**Re: Office Warehouse for McClintic RDM 9700 Trumbull, Traffic Circulation Layout**  
Engineer's Stamp dated 6-17-14 (L20-D051)

**SUBJECT: TRAFFIC CIRCULATION LAYOUT  
OFFICE WAREHOUSE FOR McCLINTIC RDM (L20-D051)  
9700 Trumbull Avenue SE  
Albuquerque, New Mexico 87123**

**Re: Office/Warehouse for McClintic RDM, 9700 Trumbull Ave SE,  
Traffic Circulation Layout  
Architect's dated 5-22-14 (L20-D051)**

**Re: Office/Warehouse for McClintic RDM, 9700 Trumbull Ave SE,  
Traffic Circulation Layout  
Architect's dated 5-12-14 (L20-D051)**

OFFICE / WAREHOUSE FOR MCCLINTIC RDM
9700 TRUMBULL S.E.
ALBUQUERQUE, NEW MEXICO.
SANDERS & ASSOCIATES ARCHITECTS, P.C. 5921 LOMAS BLVD. N.E. SUITE B ALBUQUERQUE N.M. 87110 255-5040 FAX (505) 255-5040

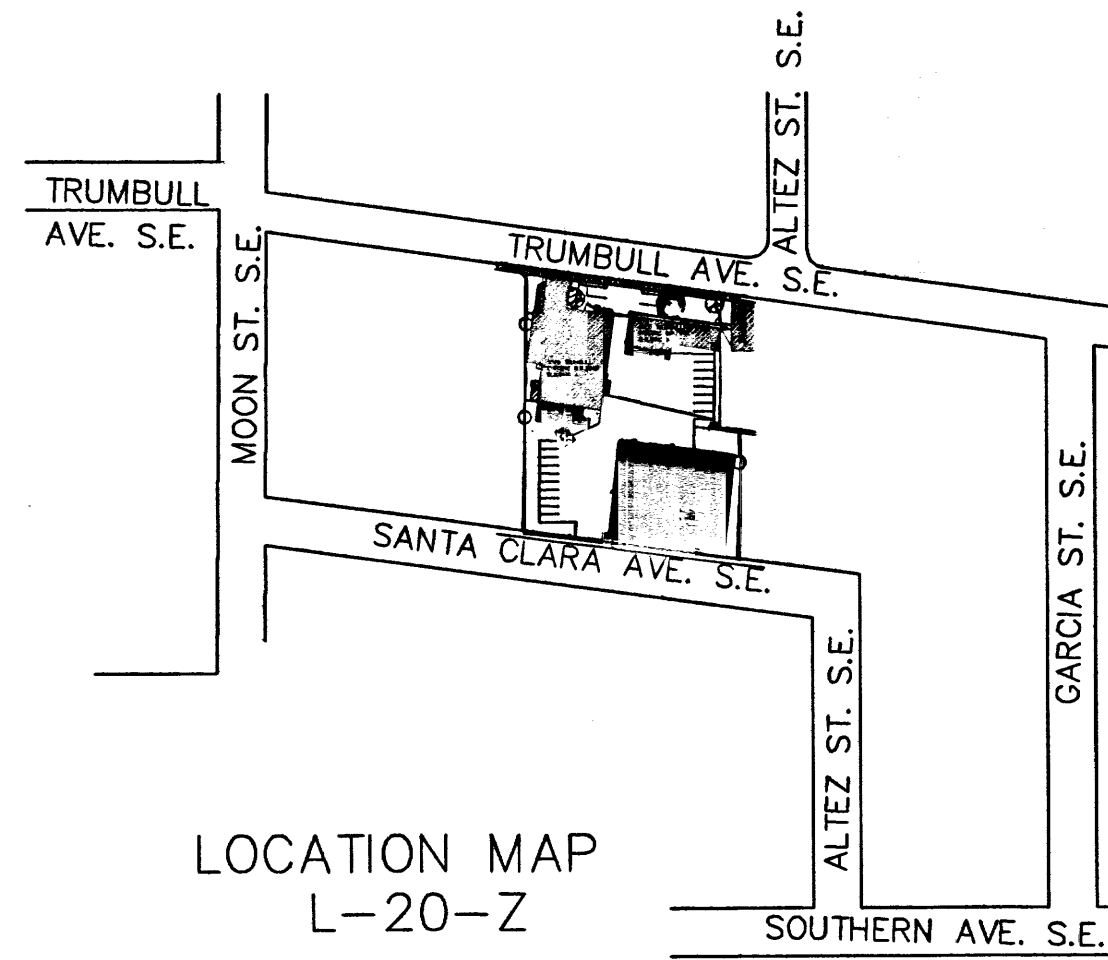
1. Please show a vicinity map.
2. The development of this site must be in compliance with current DPM and ADA standards and regulations.
3. Please refer to all applicable city standards for proposed infrastructure.

4. Please include, label and define all easements within site.
5. Per the DPM, a 6 ft. wide ADA accessible pedestrian pathway is required from the public sidewalk to the building entrances. Please clearly show this pathway and provide details.

6. Per the DPM, a 6 ft. wide ADA accessible pedestrian pathway is required from the HC parking stall access aisles to the building entrances.
7. Define width of the existing sidewalk on Trumbull.

8. List the width of the existing drivepad on Trumbull.
9. Is existing drivepad ADA compliant? Provide details. All drivepads crossing city sidewalks must provide ADA access per DPM and East Gateway SDP (5.6.1.C.4.c, p5-46)

10. Provide details or refer to the appropriate city standard for proposed 30 ft wide drivepad on Santa Clara.
11. Sidewalk, curb and gutter are required along the frontage of Santa Clara Ave. Label and provide appropriate city standards for infrastructure improvements.

12. Please place frontage sidewalk at the property line, not the back of curb.
13. Show a detail of the wheelchair ramps located at the proposed driveway, or refer to the appropriate city standard.

1. A vicinity map is provided.
2. The Plan is in compliance with DPM and ADA standards.
3. Applicable City standards are references where necessary.
4. All easements are labeled and described.

5. A 6' wide pedestrian path through the site has been added.
6. A 6' wide pedestrian path connects the handicap space to the building entrances.
7. The width of the existing sidewalk on Trumbull is labeled.

8. The existing drivepads on Trumbull are labeled.
9. ADA accessibility will be provided around the existing non-compliant Trumbull drivepad as shown by the Plan.

10. Construction of permanent street improvements within Santa Clara is beyond the scope of this project. The City of Albuquerque has utilized Santa Clara over the last 50 years to serve the Ridgecrest Pump and Reservoir Station. Well collector waterlines and 2 storm drains have been constructed during this period. The City elected to provide an asphalt street section without concrete curb, gutters or sidewalks. Underground utilities were not provided to serve the adjoining properties. As the corridor developed the properties took service from other perimeter right of ways. One of the properties has been allowed to use the roadway for access without providing permanent improvements. Imposing this requirement on this property is an undue hardship.

SITE PLAN
SCALE: 1" = 20'-0"

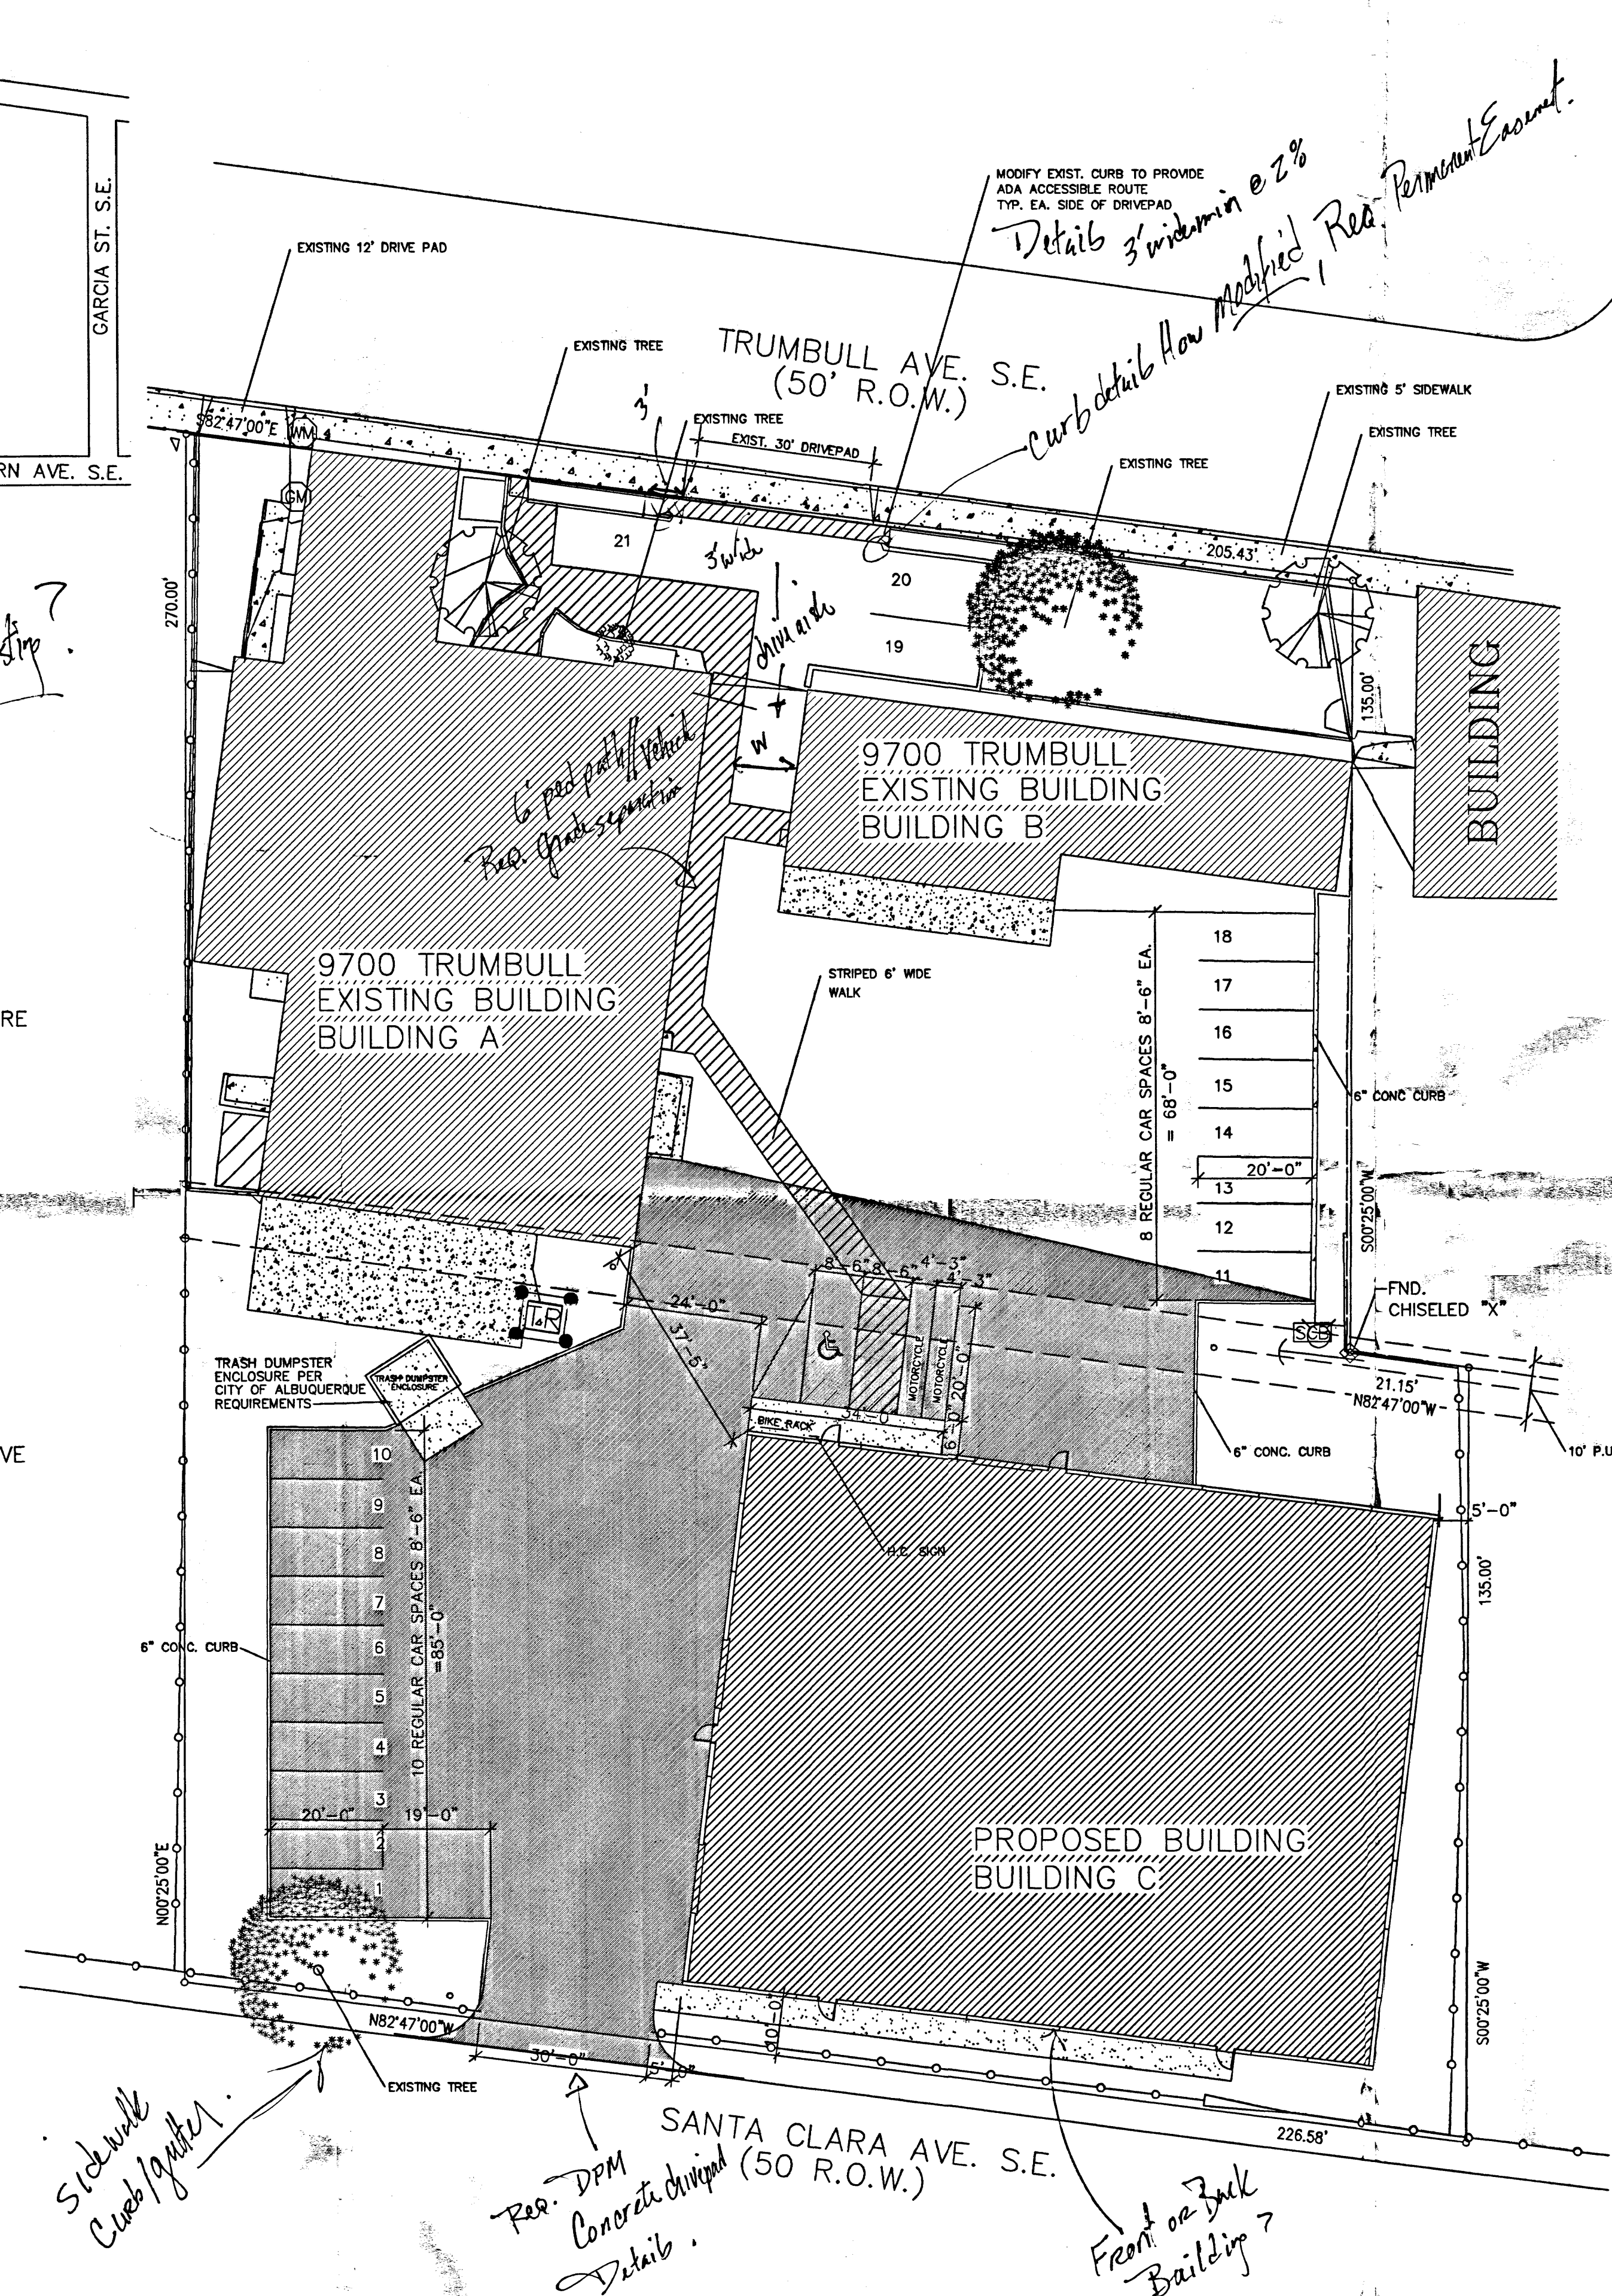
- ✓3. The proposed 6 ft wide striped pedestrian walkway from the COA ROW to the building entrances is not DPM compliant. Pedestrian pathways situated parallel to vehicular traffic must be protected by an elevation change.

- ✓4. Please dimension width between building A & B. What is the vehicular drive aisle width?
- ✓5. All driveways crossing city sidewalks must provide ADA access per DPM and East Gateway SDP (5.6.1.C.4.c, p5-46) The proposed striping and modified landscape curb to incorporate an ADA pedestrian path, set back of existing driveway on Trumbull, requires greater detail to demonstrate compliance.

- ✓6. The proposed sidewalk to back of driveway is outside of COA ROW. A permanent Sidewalk Easement will be required with proposed sidewalk.
- ✓7. Provide details or refer to the appropriate city standard for proposed 30 ft wide driveway on Santa Clara.

- ✓8. Sidewalk, curb and gutter are required along the frontage of Santa Clara Ave. Label and provide appropriate city standards for infrastructure improvements. A formal variance request to the current Traffic Engineer, Kristal Metro P.E., is required if the development can justify reason(s) for non-compliance with the DPM guidelines.

9. According to Zoning, landscaping is required with the addition of proposed 12,000 SF building C. Please provide landscaping plan with next

1. The Plan is in compliance with DPM and ADA standards.
2. Applicable City standards are referenced where necessary.
3. The proposed 6-foot wide pedestrian way has been modified to connect the new building entry to the rear entry of existing Building "A". A striped pedestrian link is also provided from the existing front entry of Building "A" to Trumbull.

4. The distance between Buildings "A" and "B" is dimensioned.
5. The project entry will be modified to provide ADA accessibility per DPM. Detail 4 is provided to detail a 3-foot wide ADA pedestrian path around the existing drivepad, within a 4-foot wide public sidewalk easement.

- ⑥ The Grant of Easement document for the public sidewalk easement will be forwarded to you when available.
7. We request a variance of the requirement to construct permanent street improvements within Santa Clara Avenue SE along the property frontage. The City of Albuquerque has utilized Santa Clara over the last 50 years to serve the Ridgecrest Pump and Reservoir Station. Well collector waterlines and 2 storm drains have been constructed during this period. The City elected to provide an asphalt street section without concrete curb, gutters or sidewalks. Underground utilities were not provided to serve the adjoining properties. As the corridor developed the properties took service from other perimeter right of ways. Several properties have been allowed to use the roadway for primary access without providing permanent improvements. This property utilizes Trumbull Avenue for primary access. The Santa Clara entry will be gated and
